Item No. **Report of the Head of Planning & Enforcement Services**

Address LAND AT REAR OF 101 AND 103 RALEIGH AVENUE HAYES

Development: Two storey 3-bed detached dwelling with associated parking and amenity space, involving installation of new vehicular crossover.

LBH Ref Nos: **68694/APP/2012/2442**

BLOCK PLAN
SCALE 1:100@A2

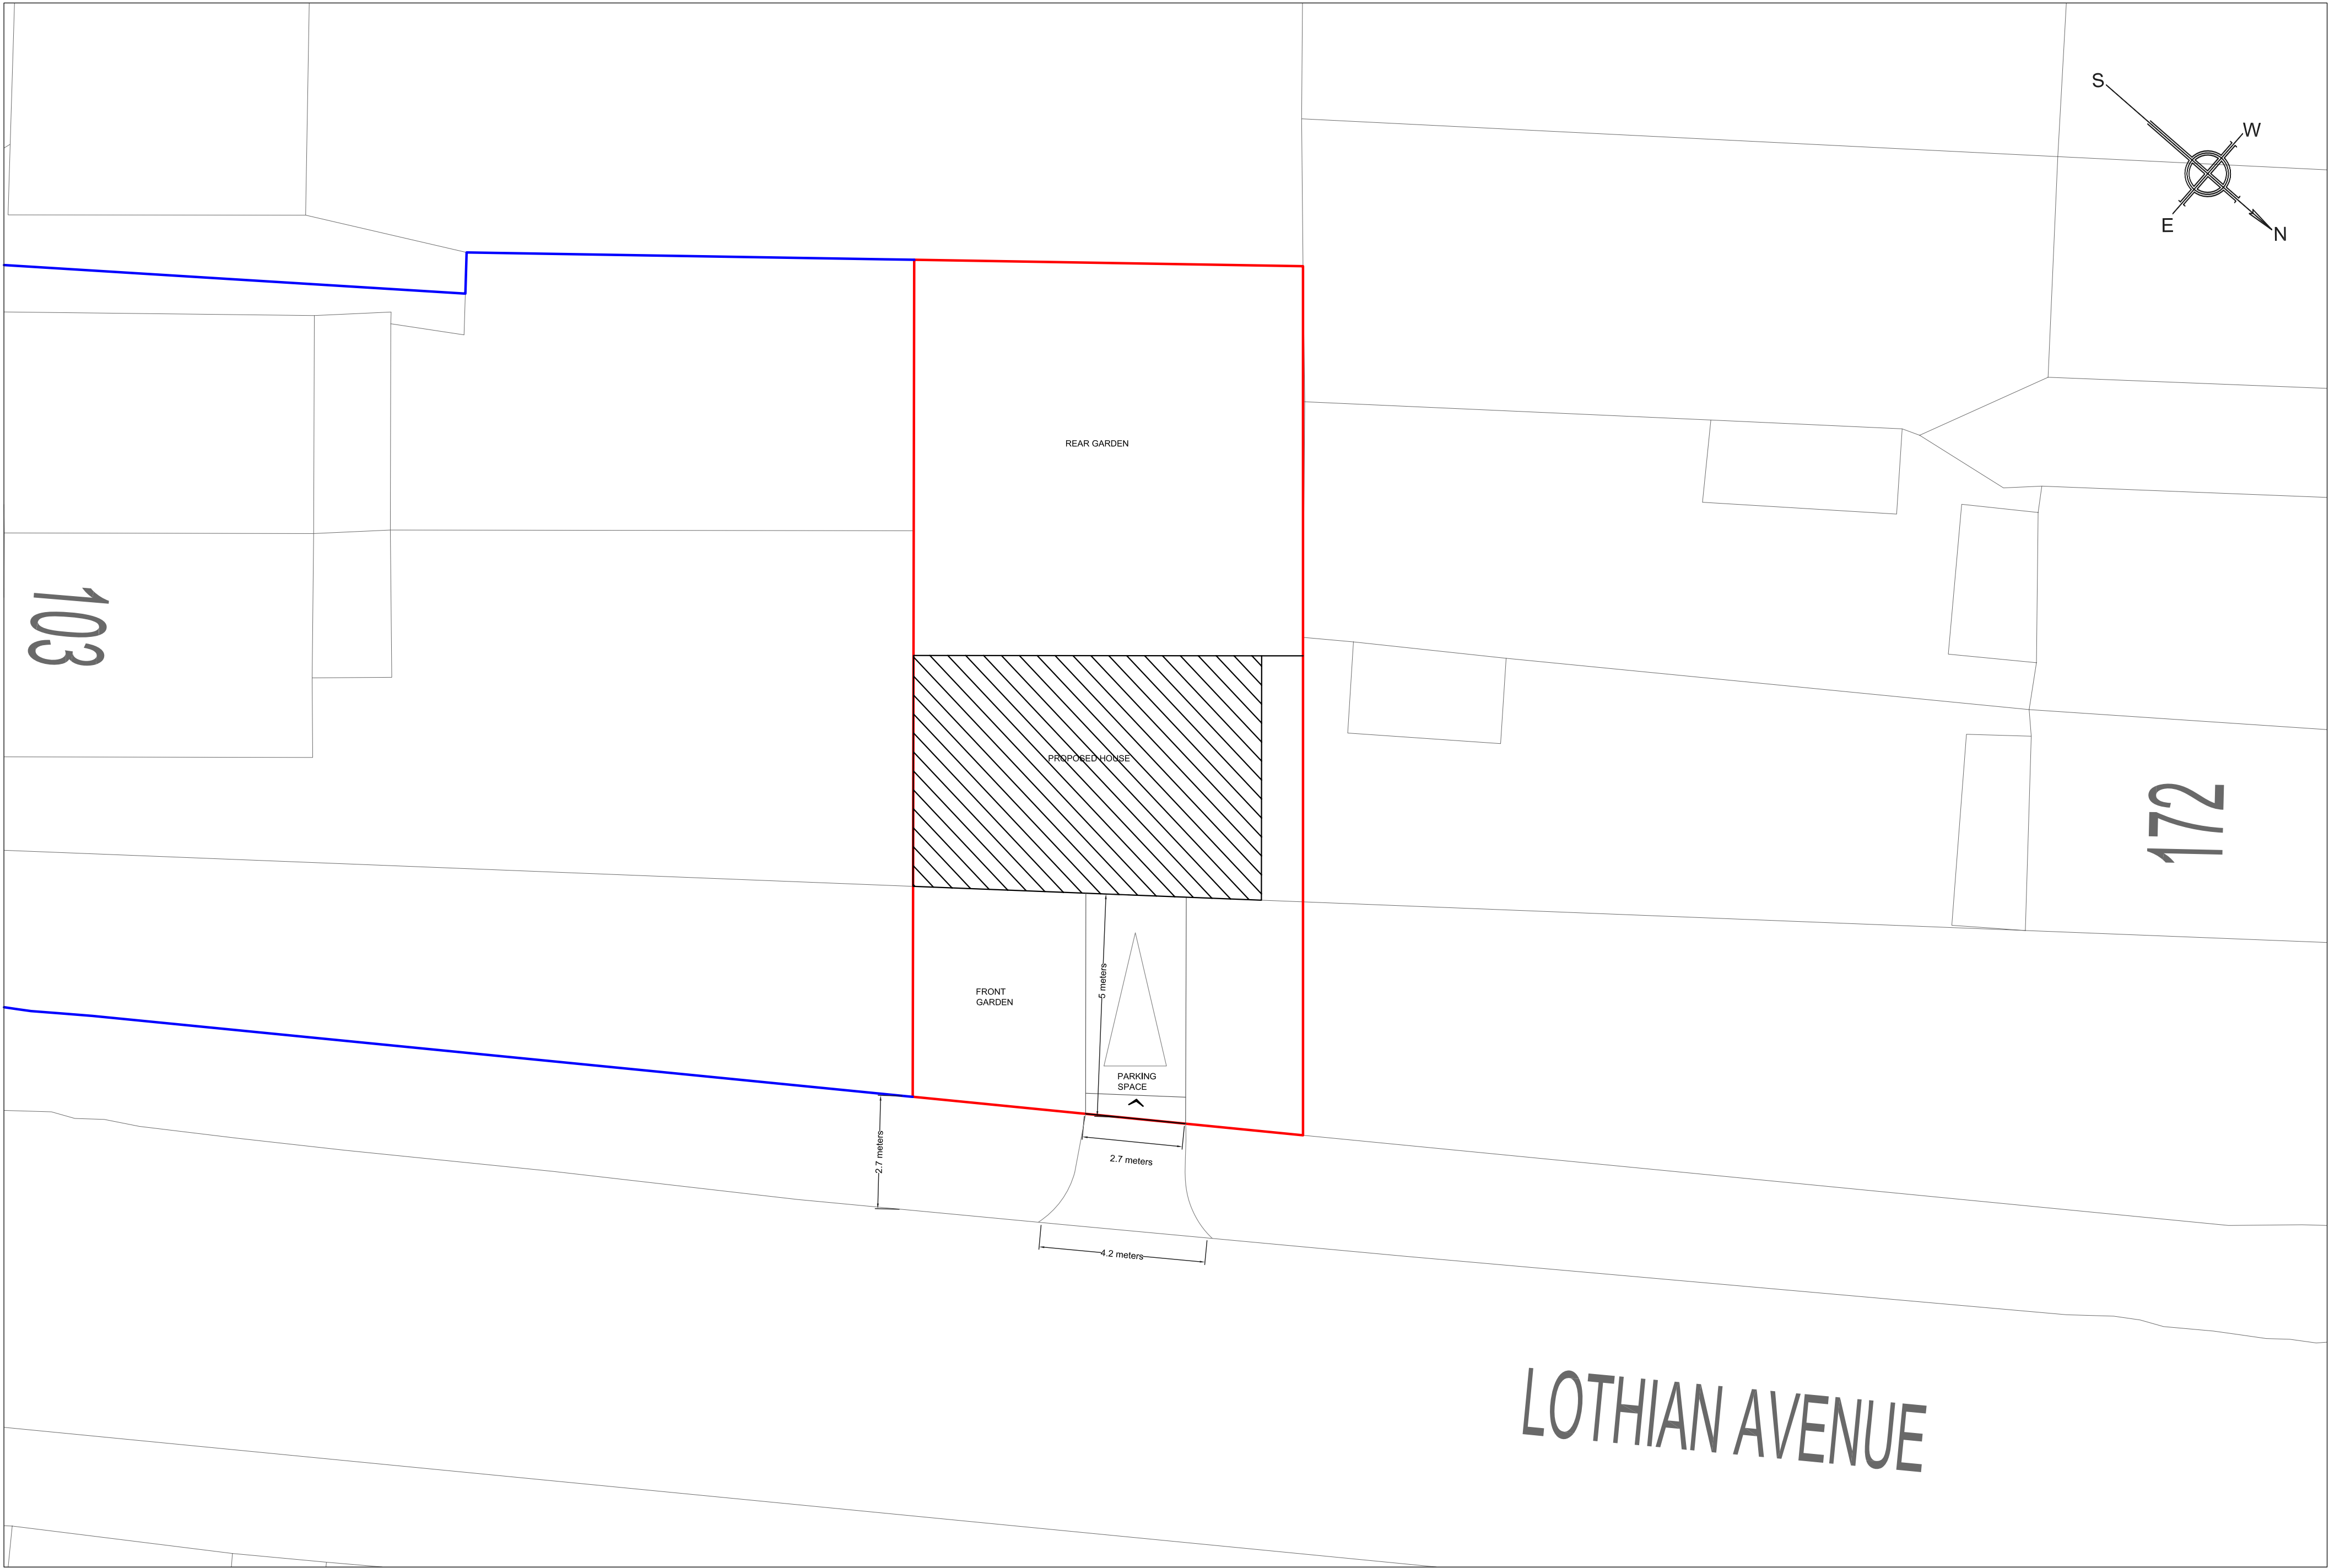
When undertaking assessment of the development it is noted that there is an extant planning consent at the site (Ref: 61910/APP/2006/3409) for the construction of a dwelling that will form a terrace with 103 Raleigh Avenue, which is currently being implemented. As a result, the proposals under the current planning application will remove 3 No. parking spaces that are required as part of the extant planning consent.

Additionally, when considering the current development proposals it is noted that the PTAL index within the area is 1b, which is classified as very poor. As a result, the maximum parking provision of 2 No. car parking spaces would be required to be provided within the boundary of the site.

Therefore, an objection is raised as the development is considered contrary to Policy AM14 of the adopted Hillingdon Local Plan, 2012 Part 2.

1. Level access should be achieved. Entry to the proposed dwelling appears to be stepped, which would be contrary to the above policy requirement. Should it not be possible, due to topographical constraints, to achieve level access, the pathway leading to the ground floor entrance door should be sloped (maximum gradient 1:21).

2. The scheme does not include provision of a downstairs WC that is compliant with the Lifetime Home requirements. To this end, a minimum of 700mm should be provided to one side of the toilet pan, with 1100mm in front to any obstruction opposite.

3. A minimum of one bathrooms/ensuite facility should be designed in accordance with Lifetime Home standards. At least 700mm should be provided to one side of the WC, with 1100mm provided between the front edge of the toilet pan and a door or wall opposite.

4. To allow bathrooms to be used as wet rooms in future, plans should indicate floor gulley drainage.
 5. The plans should indicate the location of a future through the ceiling wheelchair lift.

an extant planning consent at the site (Ref: 61910/APP/2006/3409) for the construction of a dwelling that will form a terrace with 103 Raleigh Avenue, which appears to be currently under construction. As a result, the proposals under the current planning application will remove 3 parking spaces that are shown on the approved drawings for this development and are required as part of the extant planning consent. These spaces are not shown as being replaced in a satisfactory manner.

Additionally, when considering the current development proposals it is noted that the PTAL index within the area is 1b, which is classified as very poor. As a result, the maximum parking provision of 2 car parking spaces would be required to be provided within the boundary of the site, particularly given the level of on-street parking in the area. In total the development should provide 5 parking spaces, including those required to be replaced as a result of the siting of the dwelling. One space is proposed which is considered to be a significant shortfall and would result in unacceptable on street parking to the detriment of highway and public safety.

The internal floorspace of the proposed house would be approximately 82sq.m which would not meet the requirements of the London Plan 2011, which requires 96sq.m for a dwelling with three bedroom, five person occupancy. As such, the proposal would not provide an acceptable standard of residential amenity for its future occupiers.
